Project #: 1008134

Project Name: LANDS OF SALAS PROPERTIES, LLC

**HYDROLOGY DEVELOPMENT SECTION
DEVELOPMENT REVIEW BOARD MEMO**

DEVELOPMENT REVIEW BOARD – SPEED MEMO

**ARCHITECTURAL
 SITE PLAN**
 SHEET NO:
AS-101

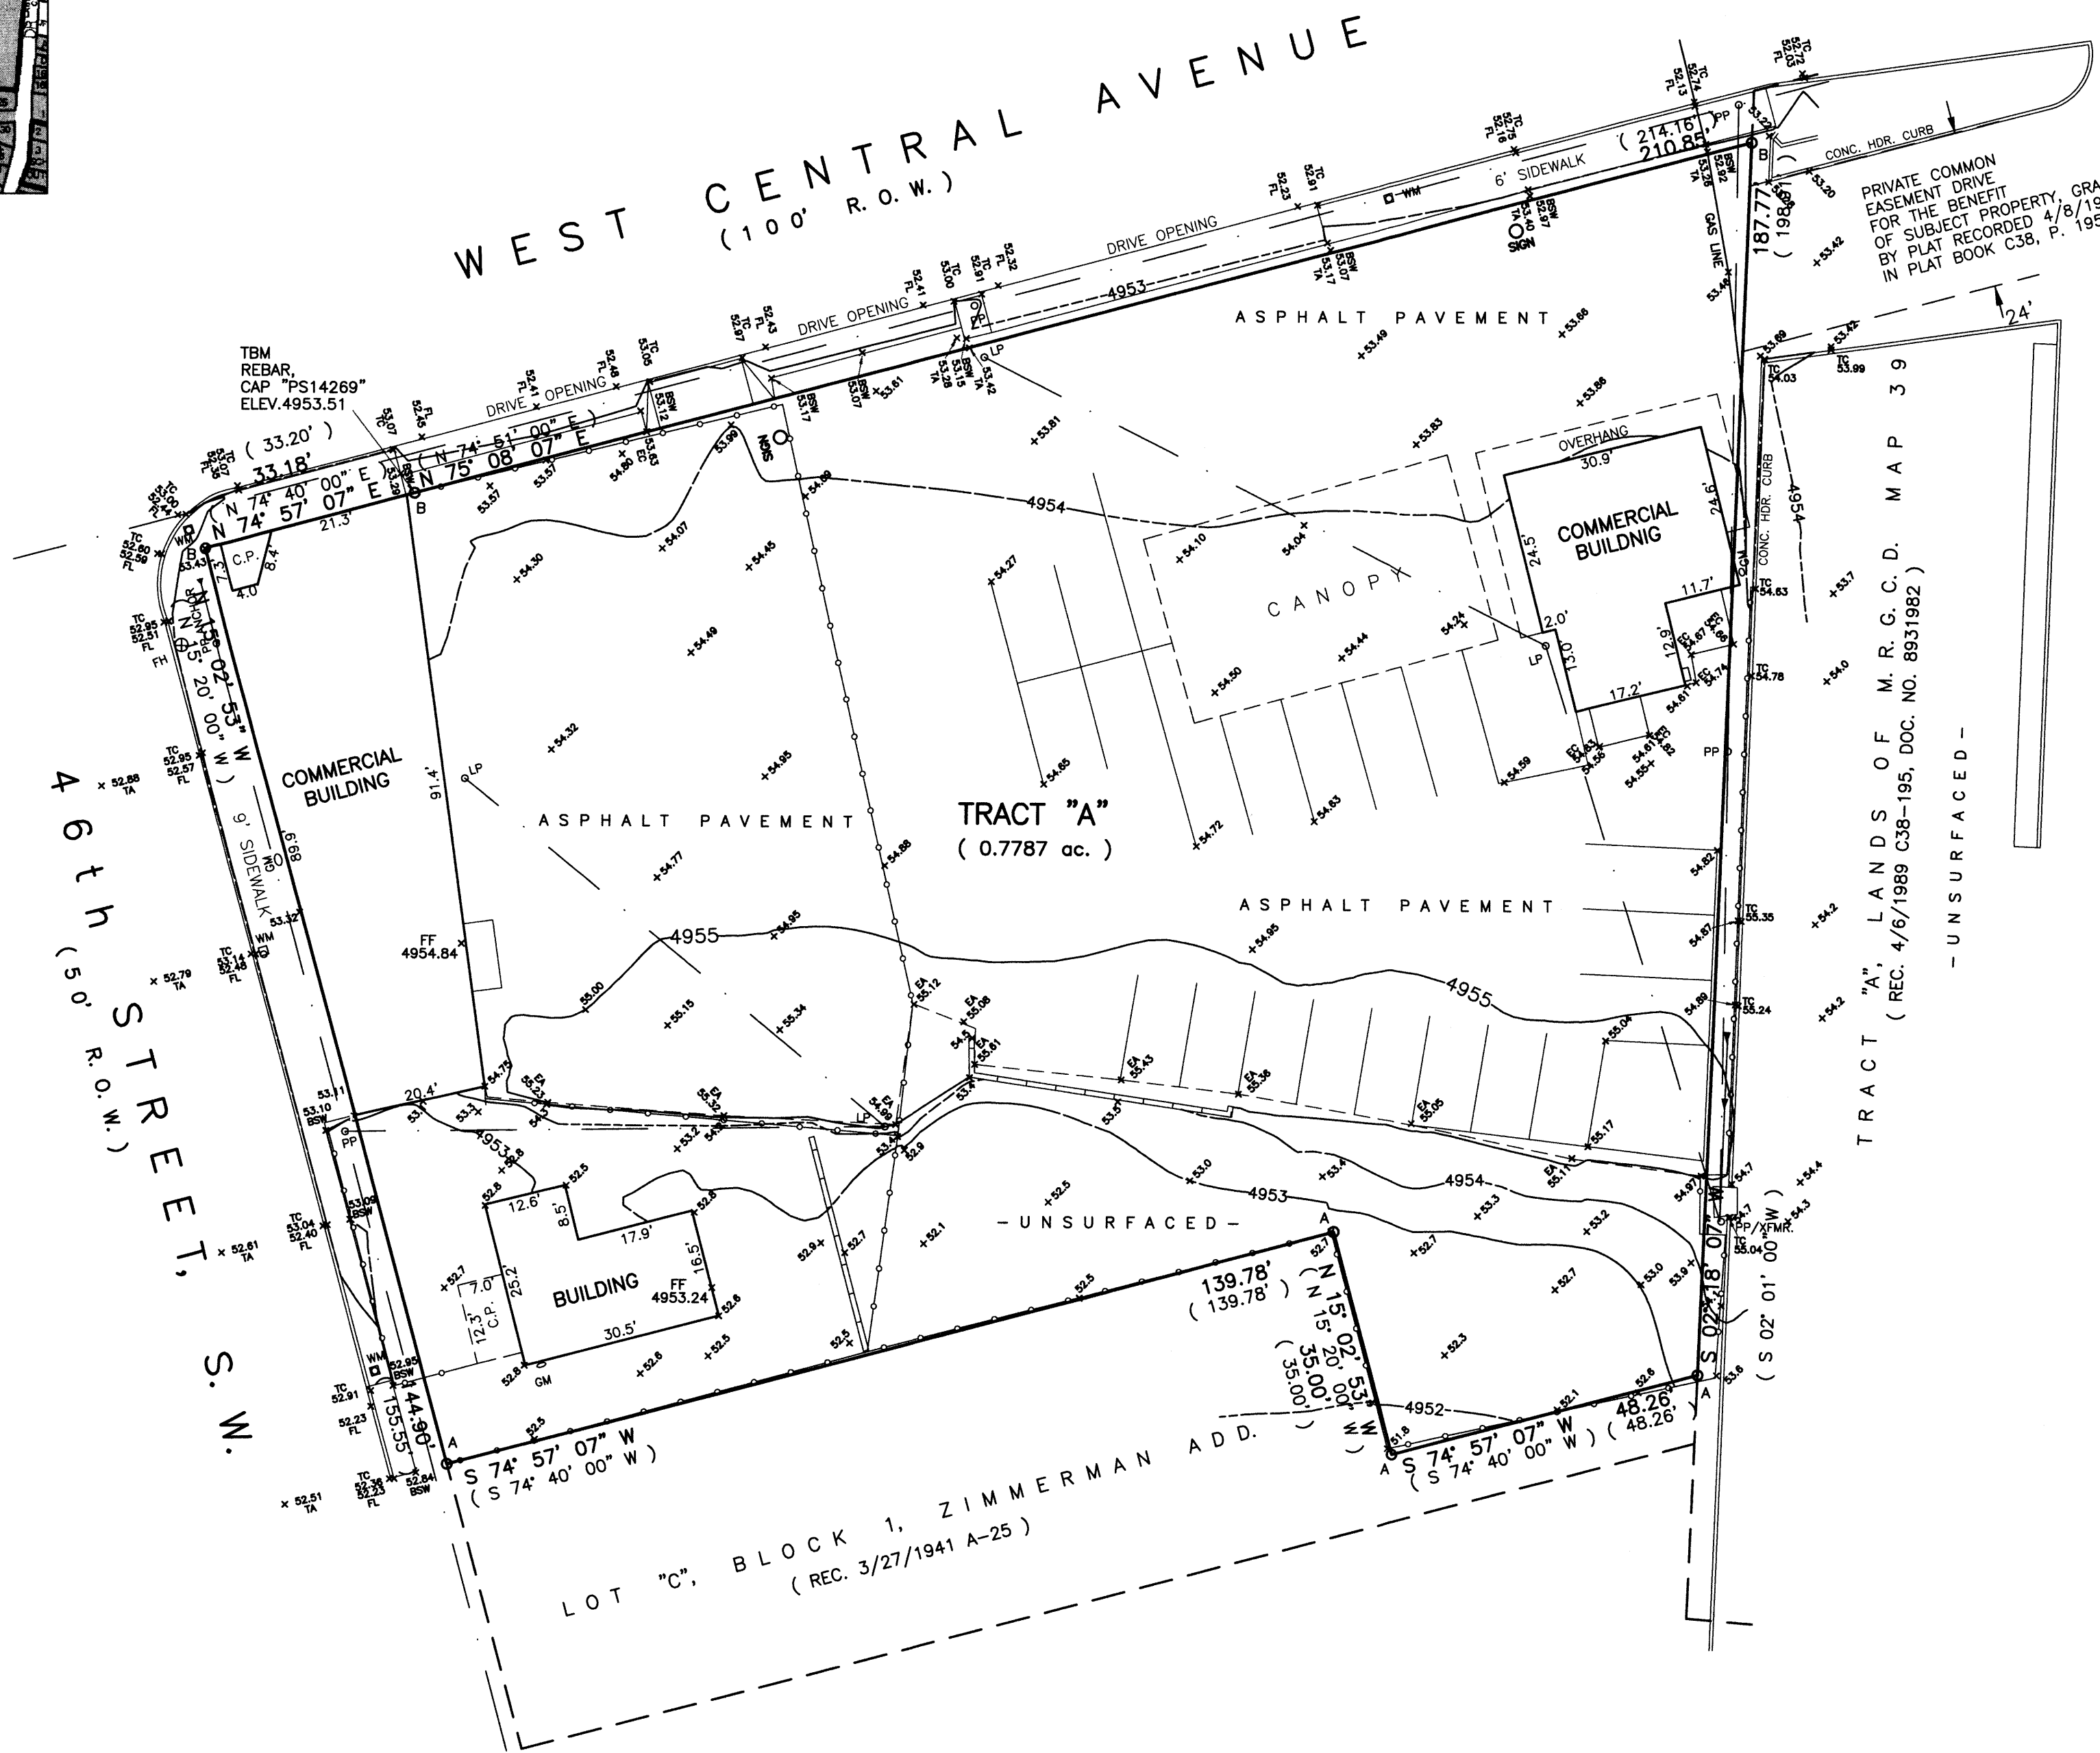
Will existing fencing be removed?

The proposed entrance off of 46th Street must be built to CoA standard specifications. Please revise.

The access easement appears to be misaligned; please clarify.

Ramps located with City of Albuquerque right of way or public easement must have truncated domes.

PRELIMINARY GRADING AND UTILITY PLAN

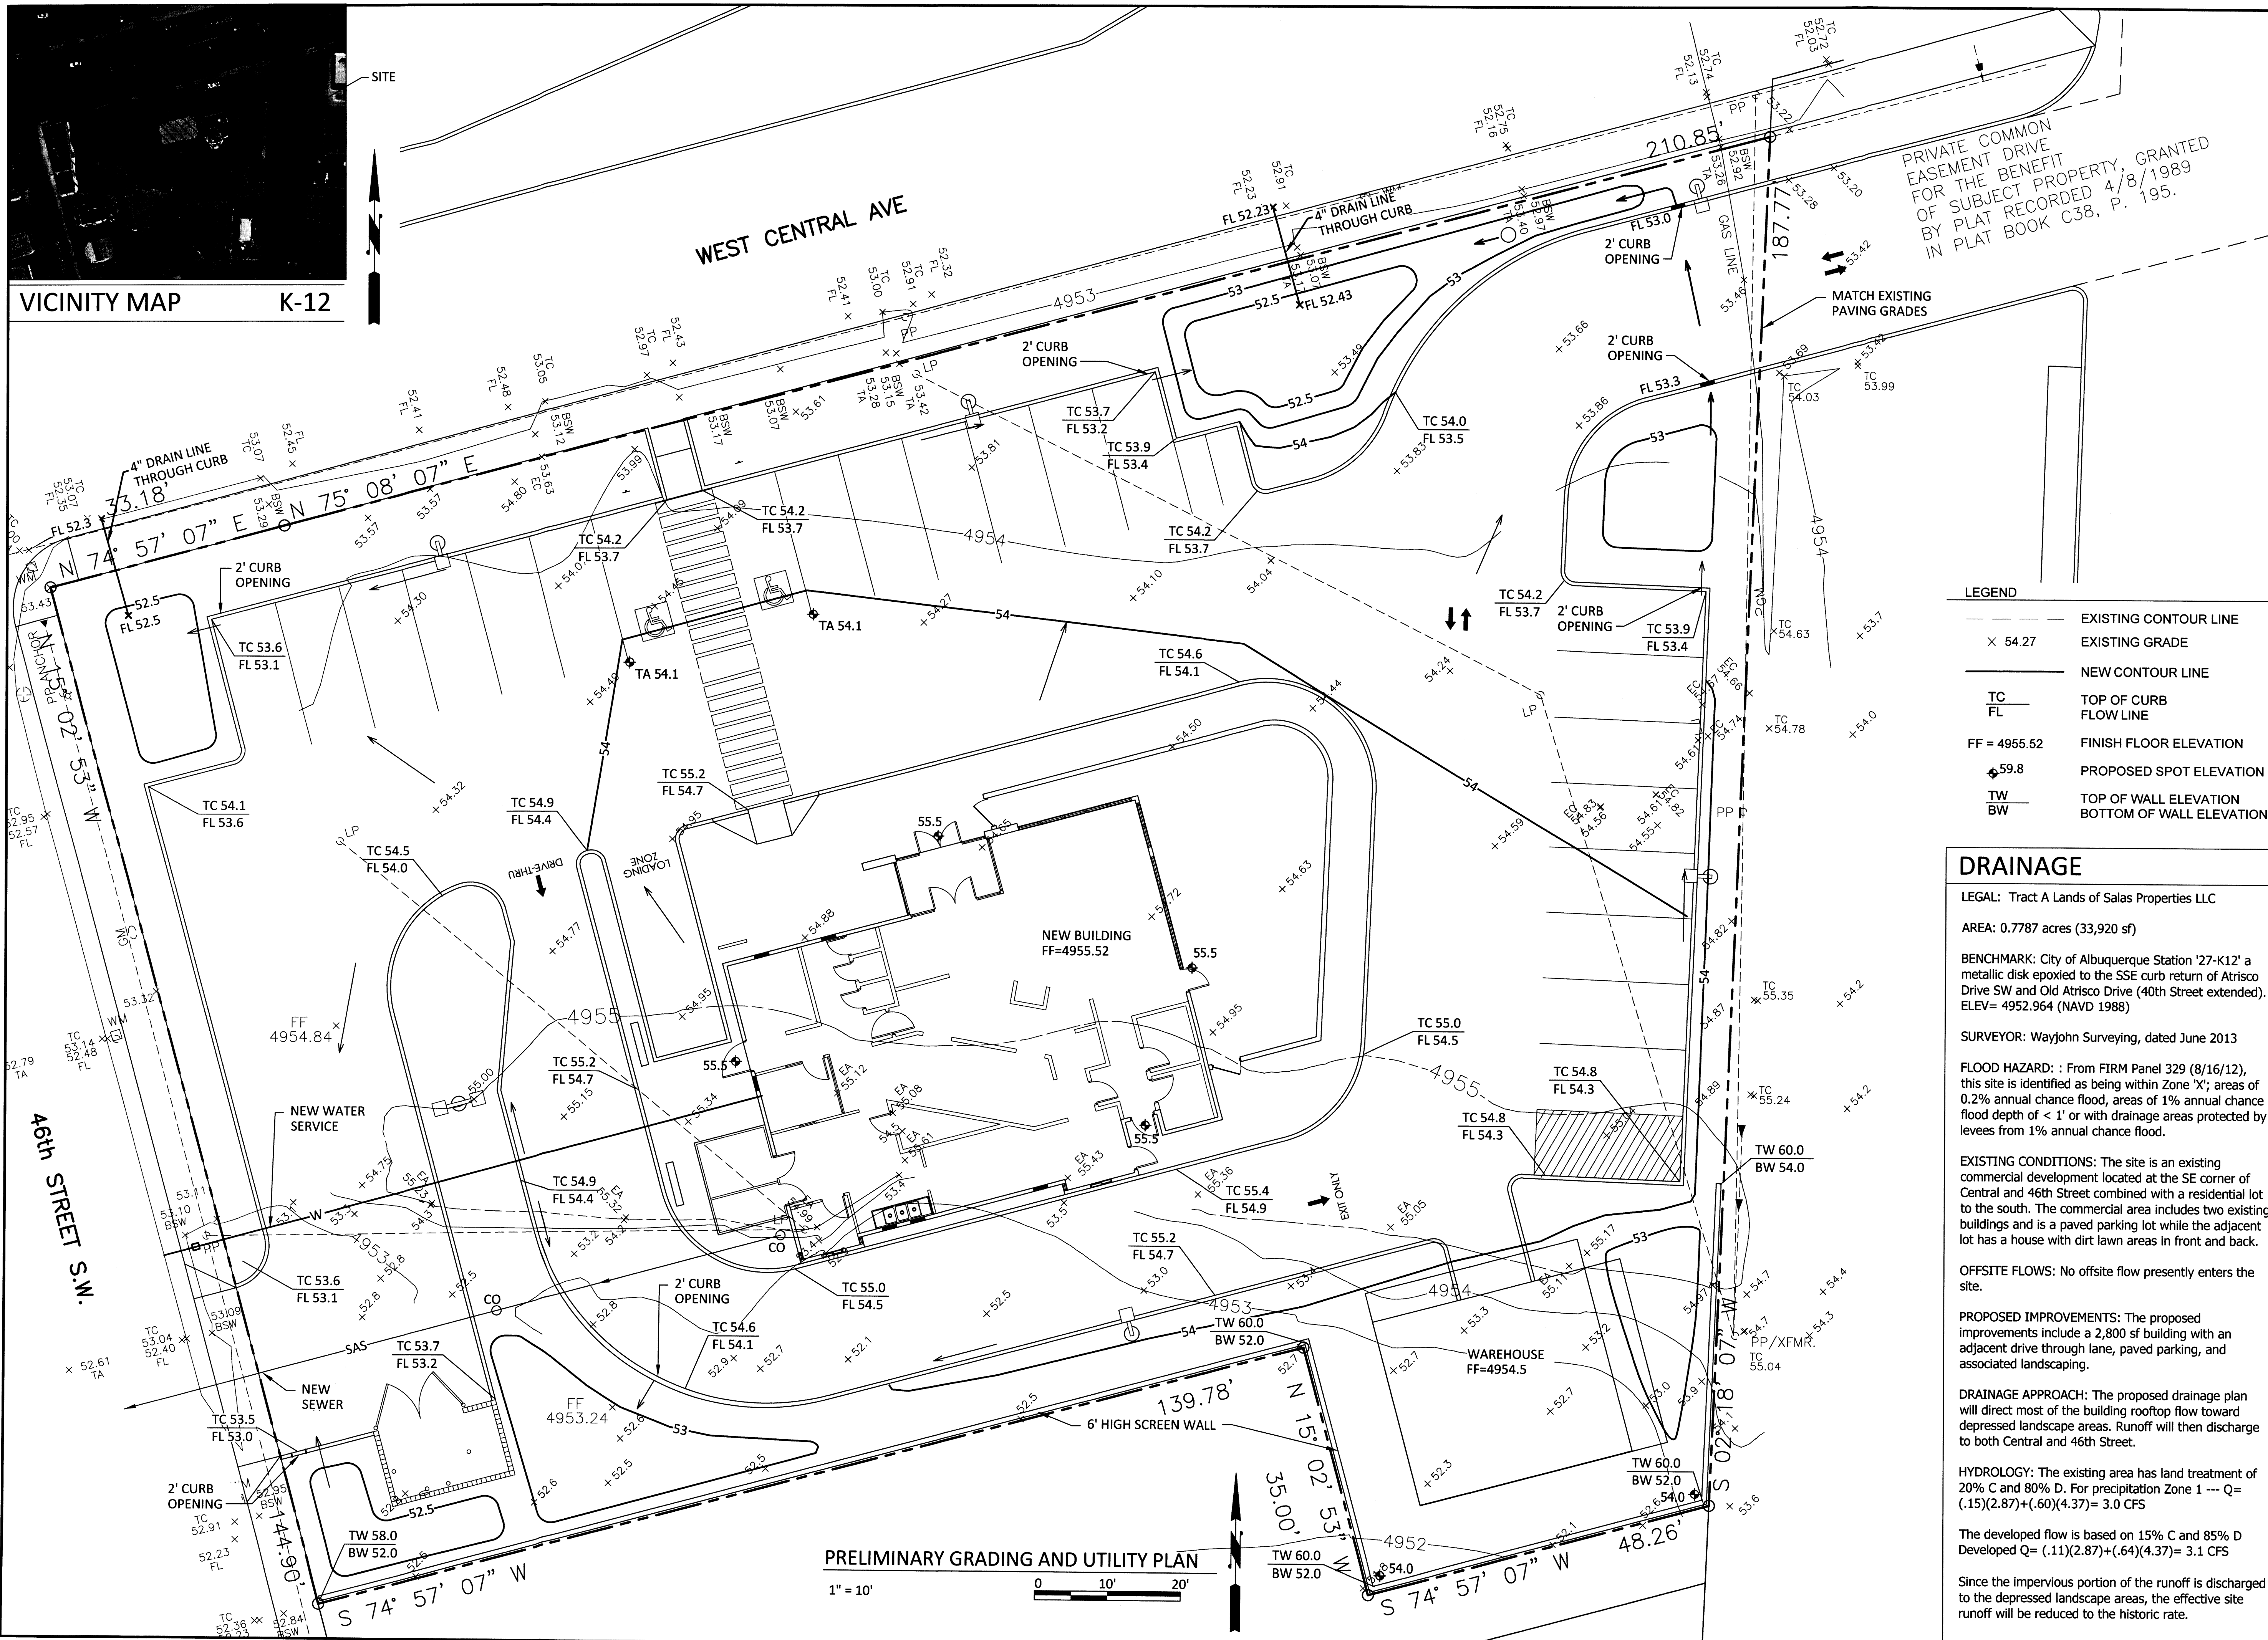
A drainage easement is required on Lot A or a high point could be built to drain the site to Central Ave.

The warehouse building in the southeast corner should drain to the parking lot.

An approved conceptual grading and drainage plan is required.
